I, Sarah Howard of [REDACTED] Anna Bay, strongly **OBJECT** to the proposed development application SSD-5916. As someone who grew up on an adjoining block to the proposed development, I find that there are many unanswered questions and multiple inconsistencies in the abovementioned DA. This land was owned by many previous generations of my family, and has been an incredible part of my growing up in a rural lifestyle. My young family and I still regularly spend a large amount of time at 4181 Nelson Bay Road, both spending time with my parents and sister (and her family), or our children being looked after by the family. In reading the DA, it is apparent that it is not only going to severely impact my extended family and their neighbours, but is also not compatible with the idea of a 'eco tourism' nor is it something the community wants or needs.

Please see below some more specific objections to the proposed DA SSD-5916.

TYPICAL EXTERNAL ROAD SECTION

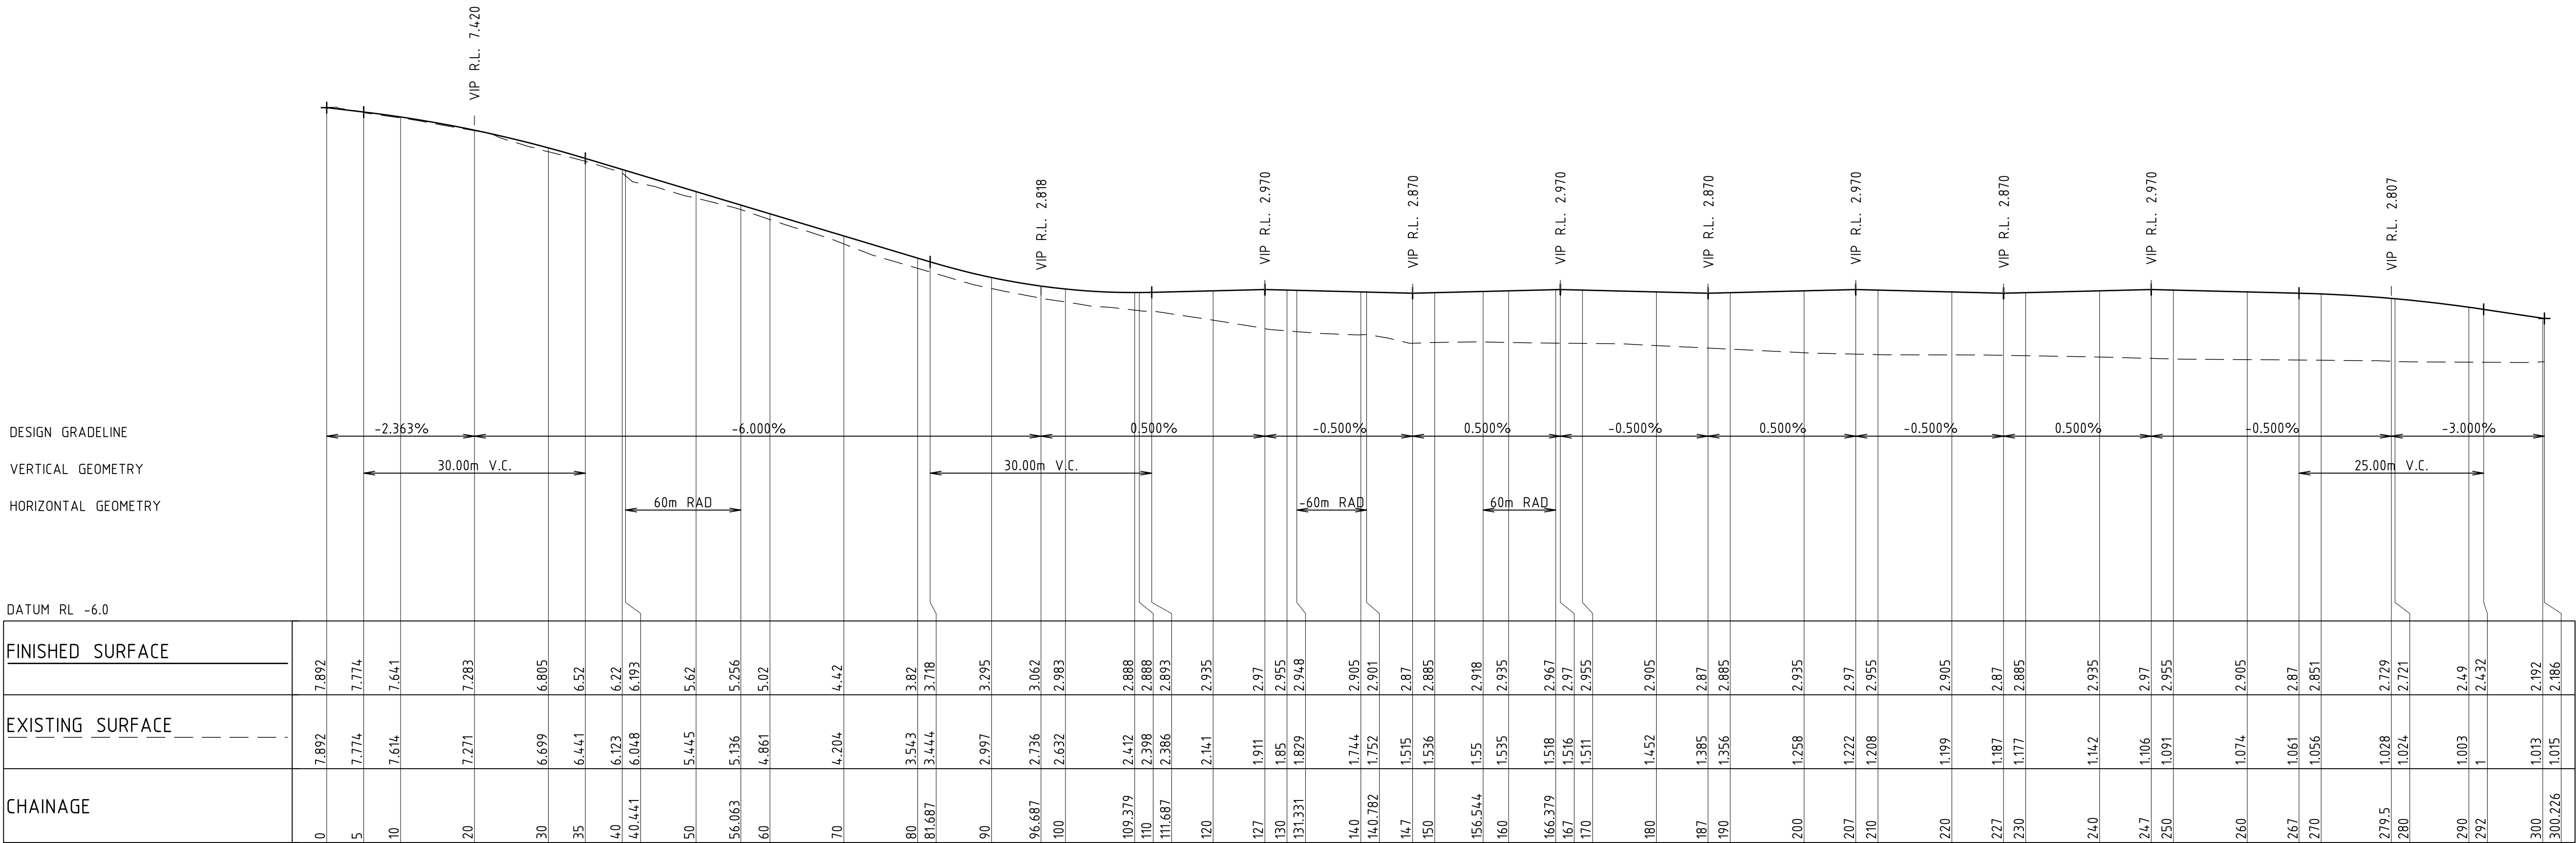
- Here are some specific areas which will directly impact 4181:
A: Pedestrian footpath and two-lane road less than 10m east of my sister's front door
B: 112 space carpark, raised to 3m, dominating the landscape in their northern

C: Proposal to move the bus stop directly across my parent's driveway, blocking their direct access to Nelson Bay road.

- ALSO- the plan shows the driveway of 4181 being removed and replaced with a bus stop. There has been no communication regarding this- how can they simply remove a legal driveway without either discussing it or offering a solution? Nor an acknowledgement of the impact it will have on my parents?
